Re: Certification Submittal for Final Building Certificate of Occupancy for
RB's Auto Sales, [H-18 / D34]
5700 Menaul Blvd NE
Engineer's Stamp Dated 07/25/05

RB's Auto Sales/Office

Re: Office – RB's Auto Sales, 5700 Menaul Blvd NE, Traffic Circulation Layout
Engineer's Stamp dated 8-24-04 (H18-D34)

**Re: Office – RB's Auto Sales, 5700 Menaul Blvd NE, Traffic Circulation
Layout
Engineer's Stamp dated 8-24-04 (H18-D34)**

Traffic Circulation Layout

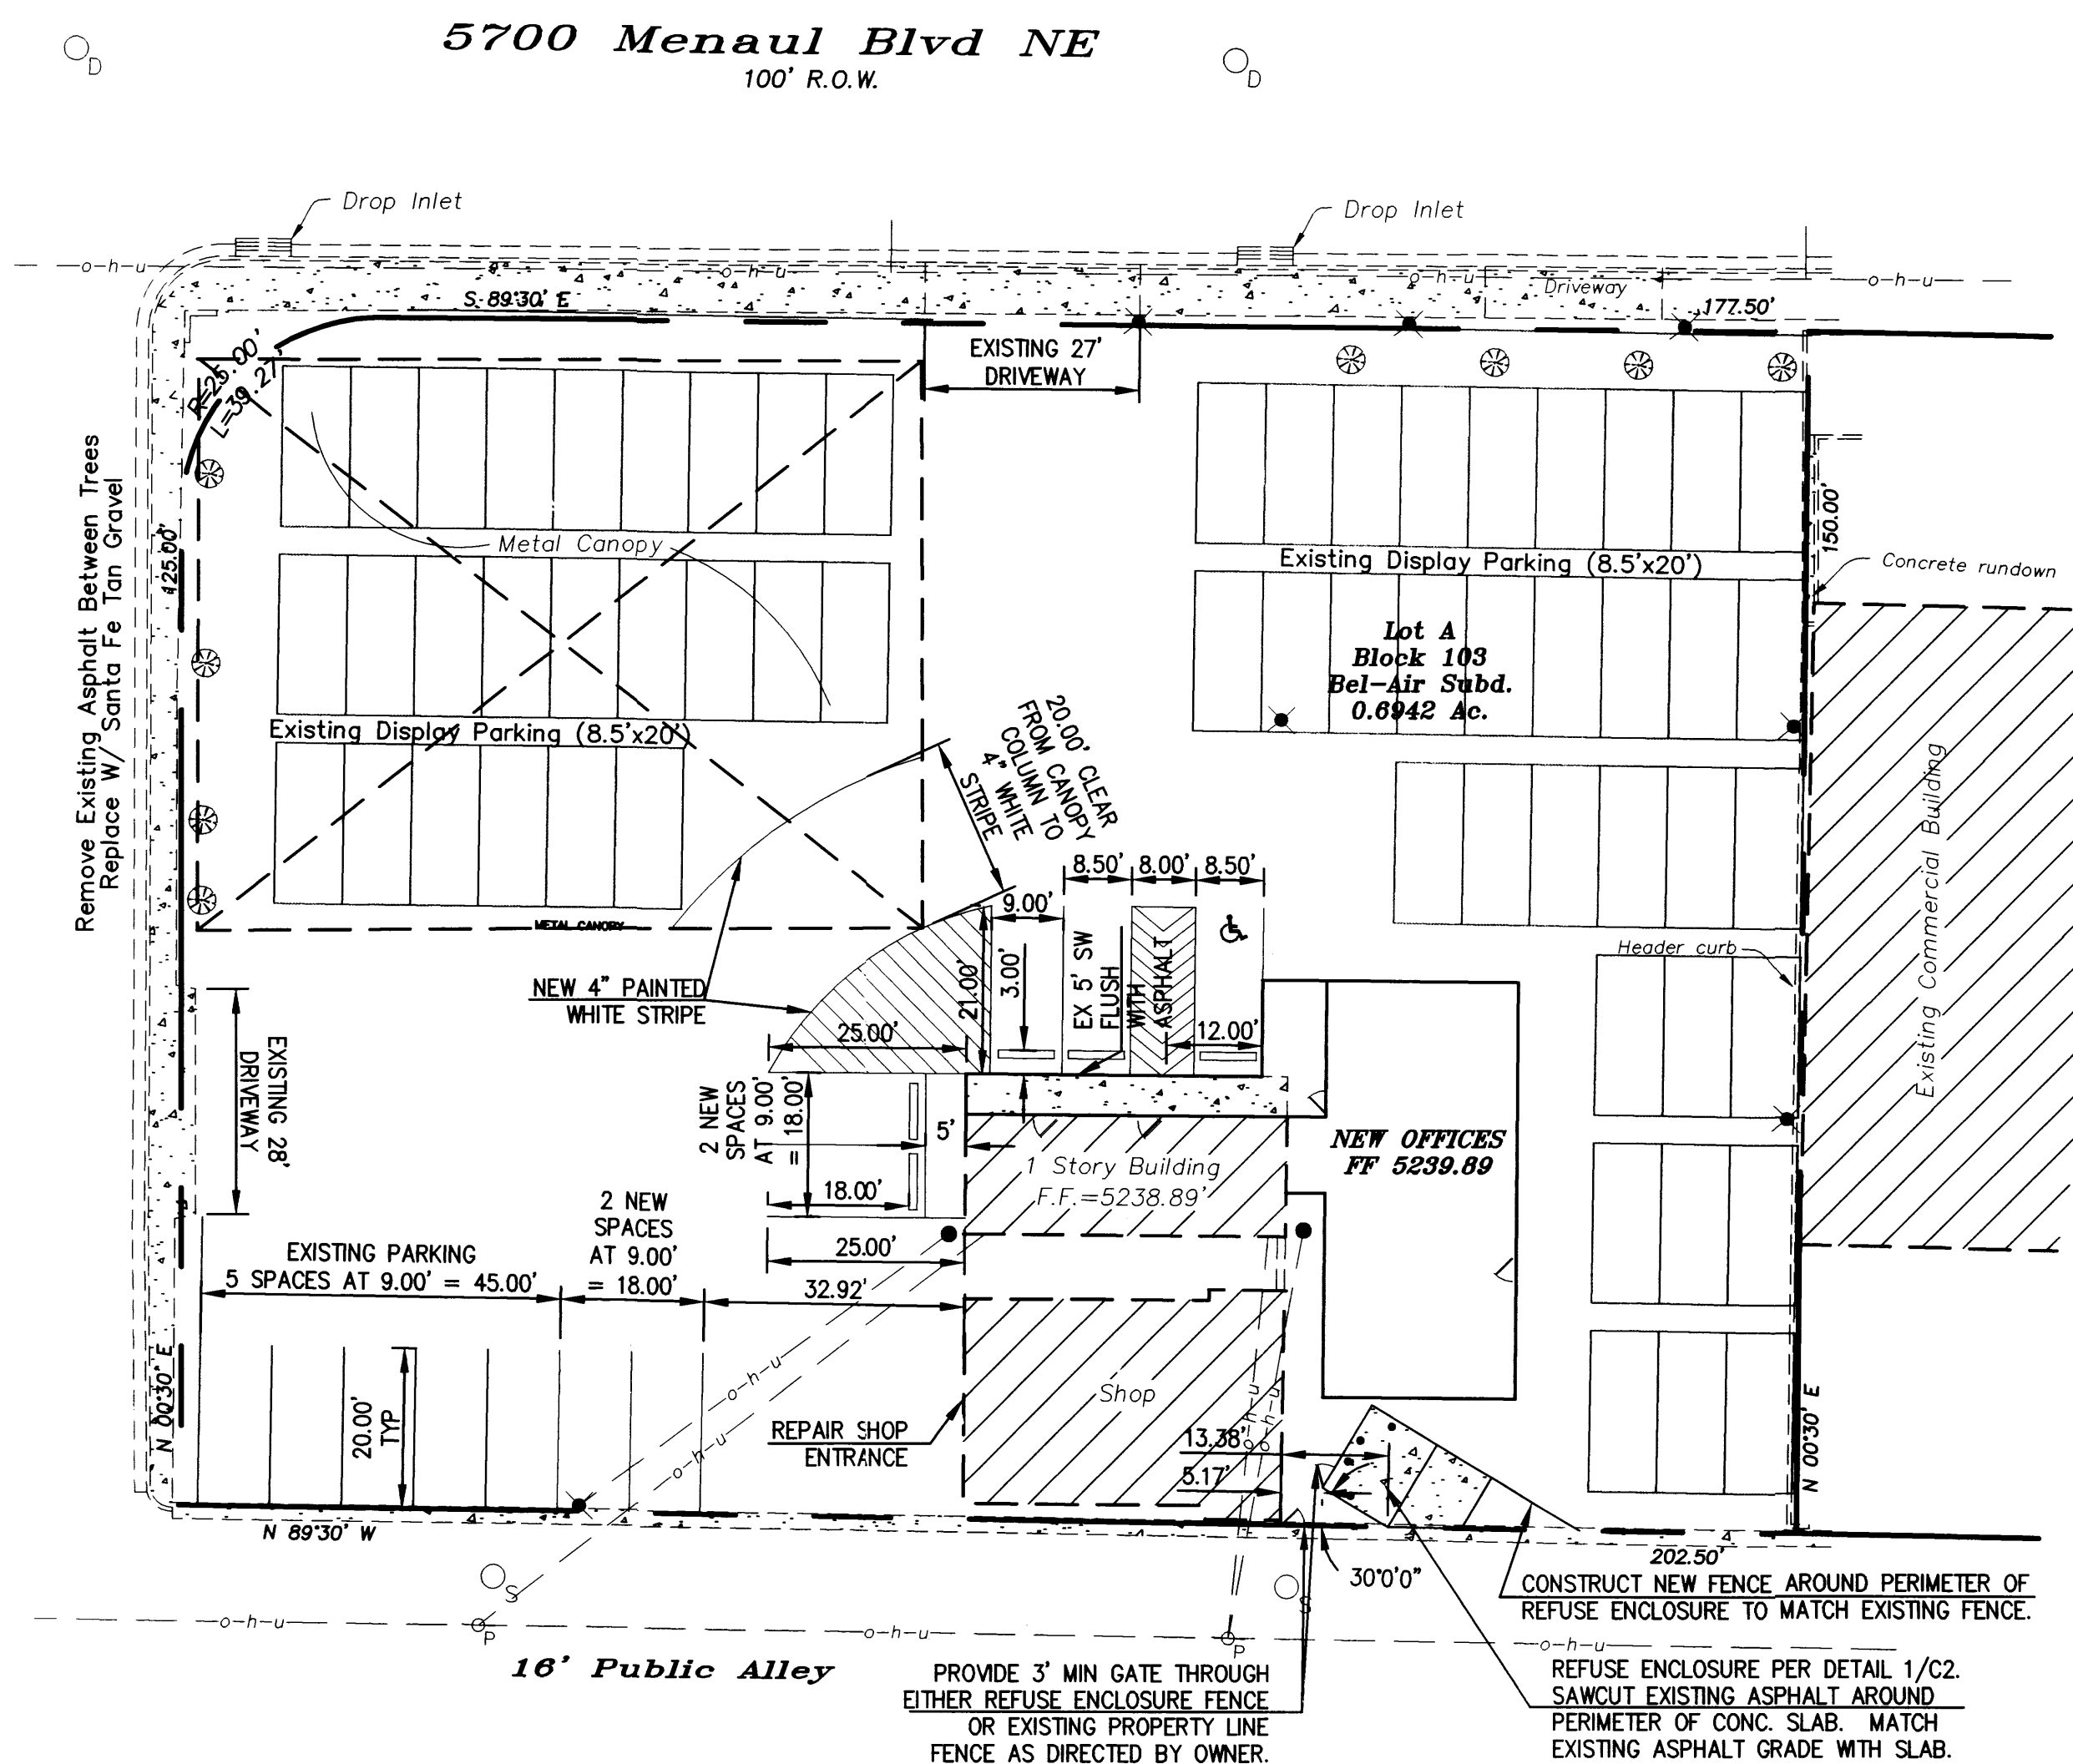
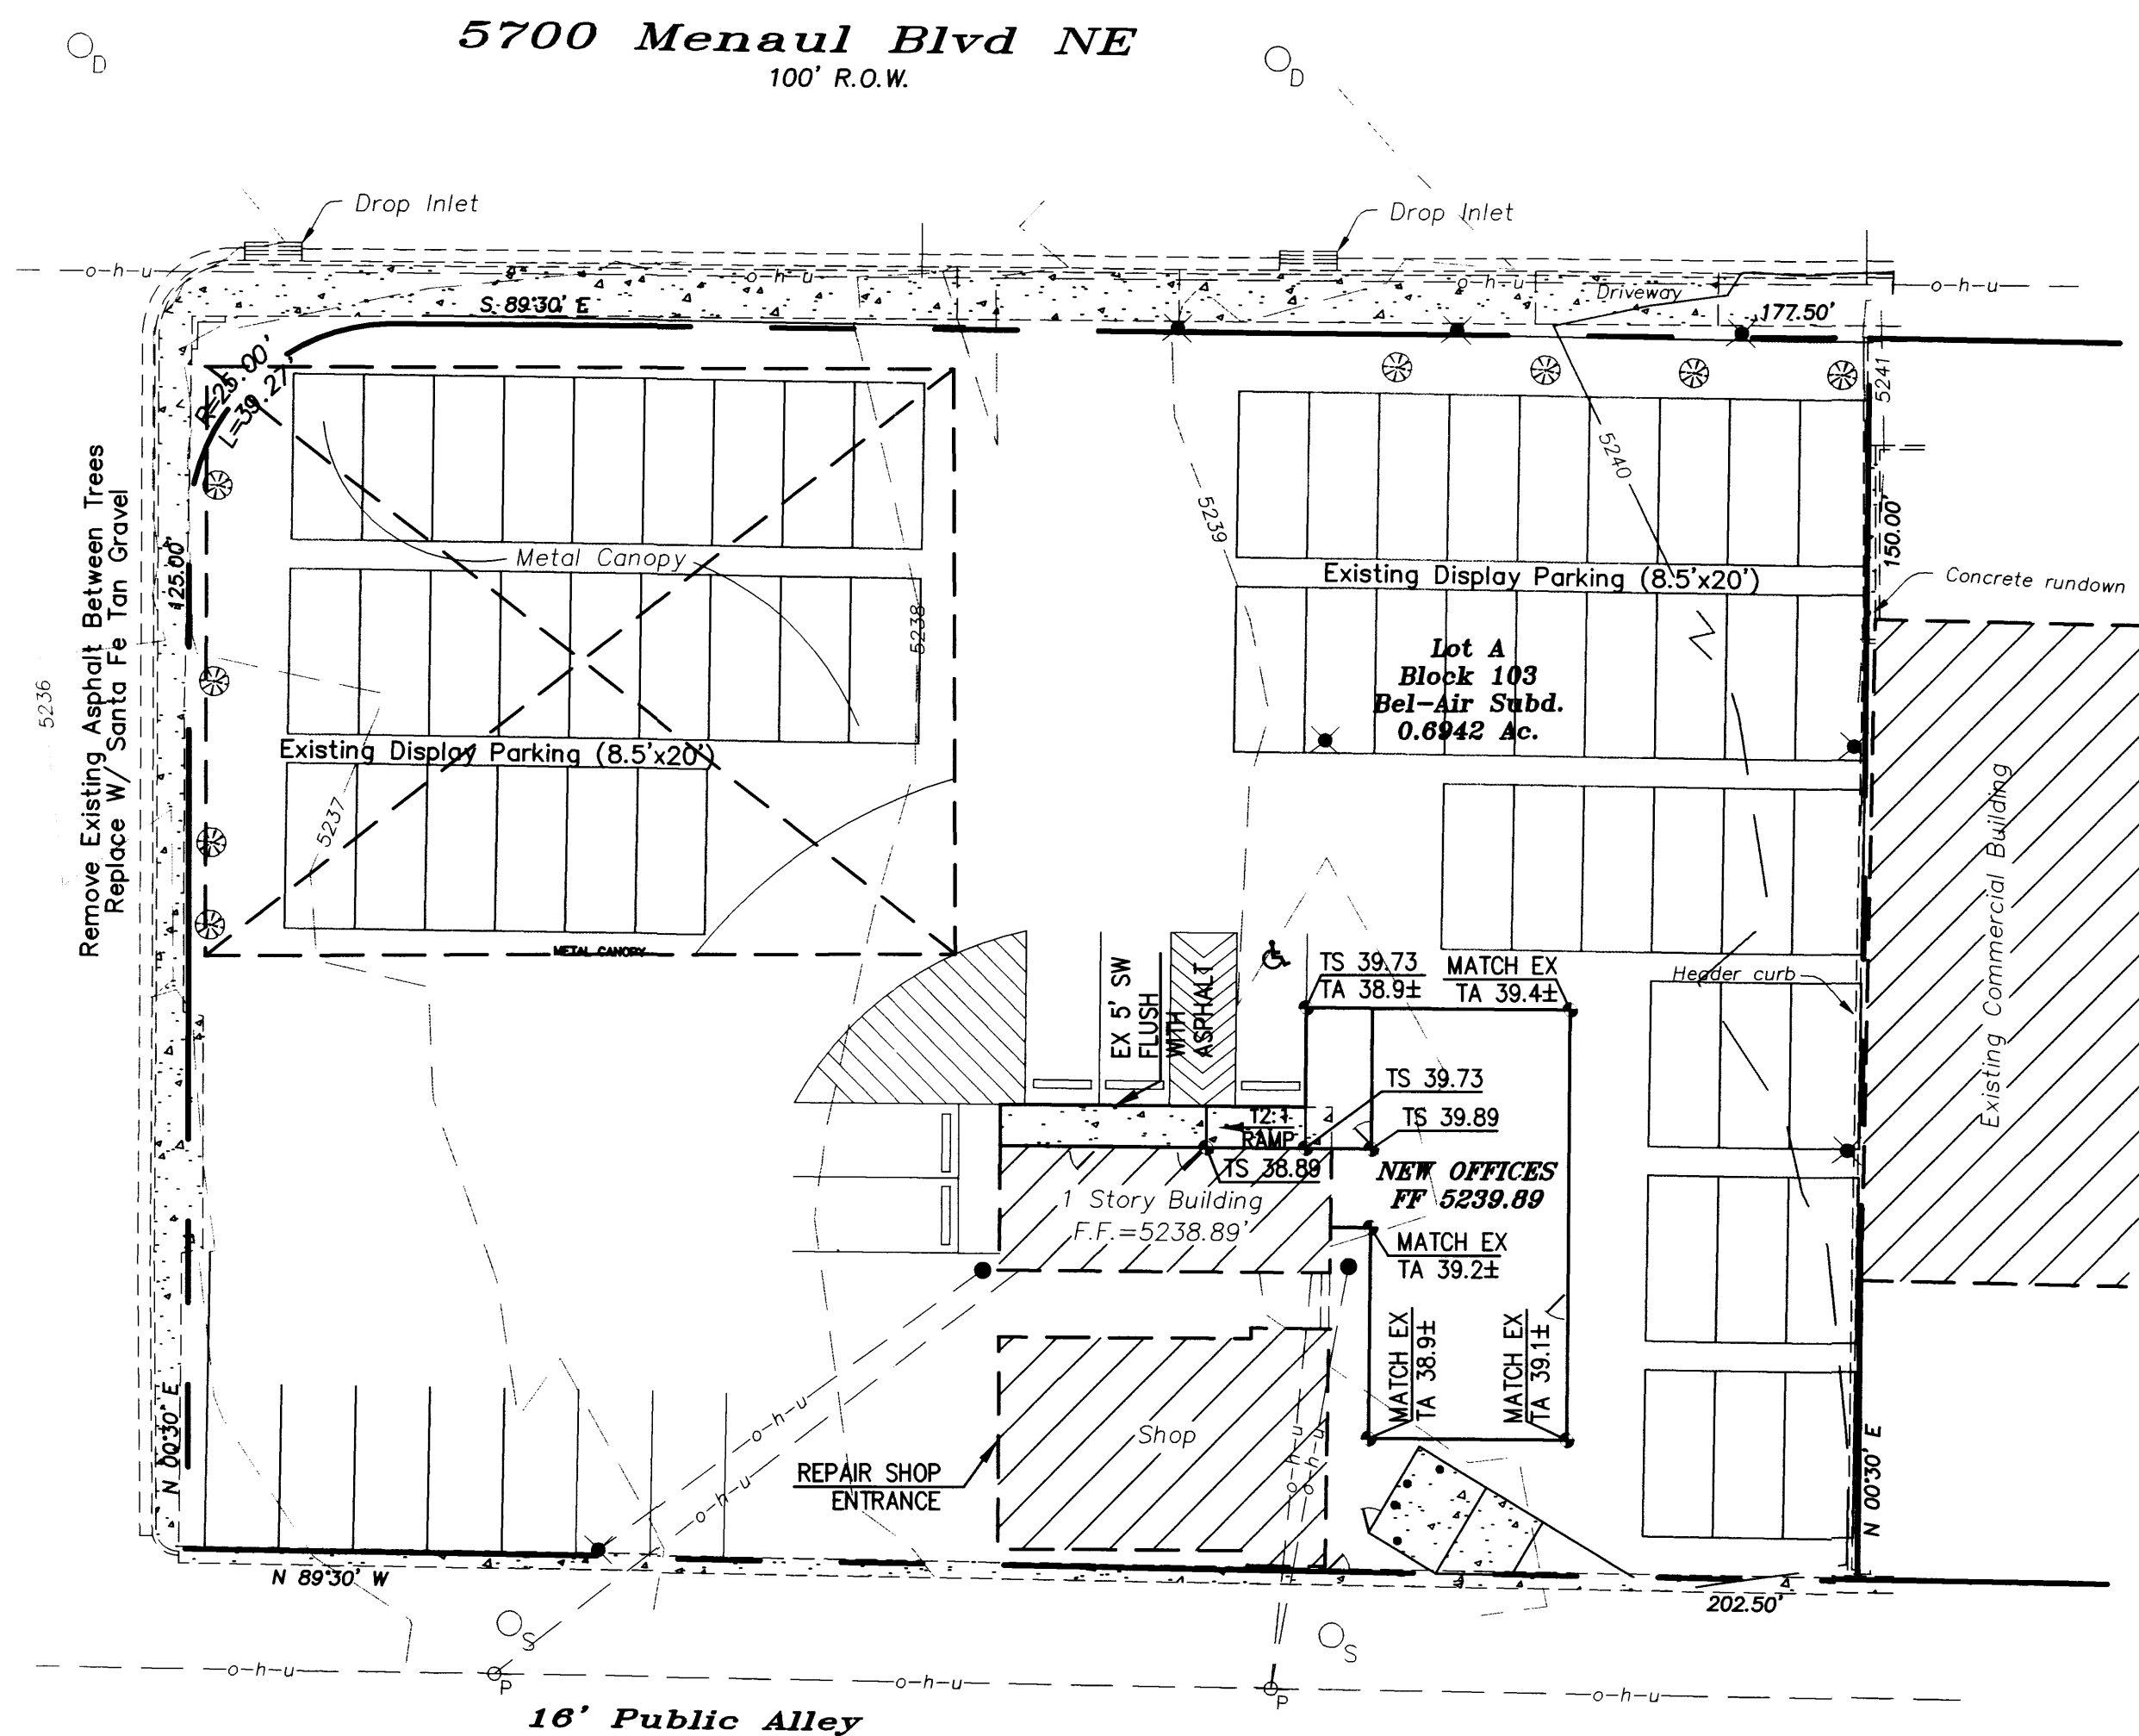
- ✓ 1. Please include two copies of the traffic circulation layout at the next
submittal.
- ✓ 2. Is the refuse enclosure accessed through the alley? If so, please verify that
the alley is paved, and provide written approval from Solid Waste.
- ✓ 3. Provide bumpers for the proposed parking spaces located parallel to the
alley, to prevent vehicles from crossing into the public right of way.

- 1. Two copies of the TCL with comments addressed are attached. Drainage has approved this plan set.
- 2. The alley is paved and is now called out on the plans as such. A written request from Solid Waste has been requested. If you do not receive a letter direct from them in the next few days, please let us know so we can follow up on getting it to you.
- 3. There is an existing 6' fence separating the alley from the parking spaces. Per our previous phone conversation, a note to that effect has been added to the plans.

In accordance with your letter dated August 25, 2004, we have requested written approval from Solid Waste for servicing this property from the alley. This is in accordance with the current pickup schedule and location. We have met with Solid Waste to discuss the size and location of the refuse enclosure. By signing below Solid Waste approves utilizing the alley to pick up refuse from a roll out receptacle.
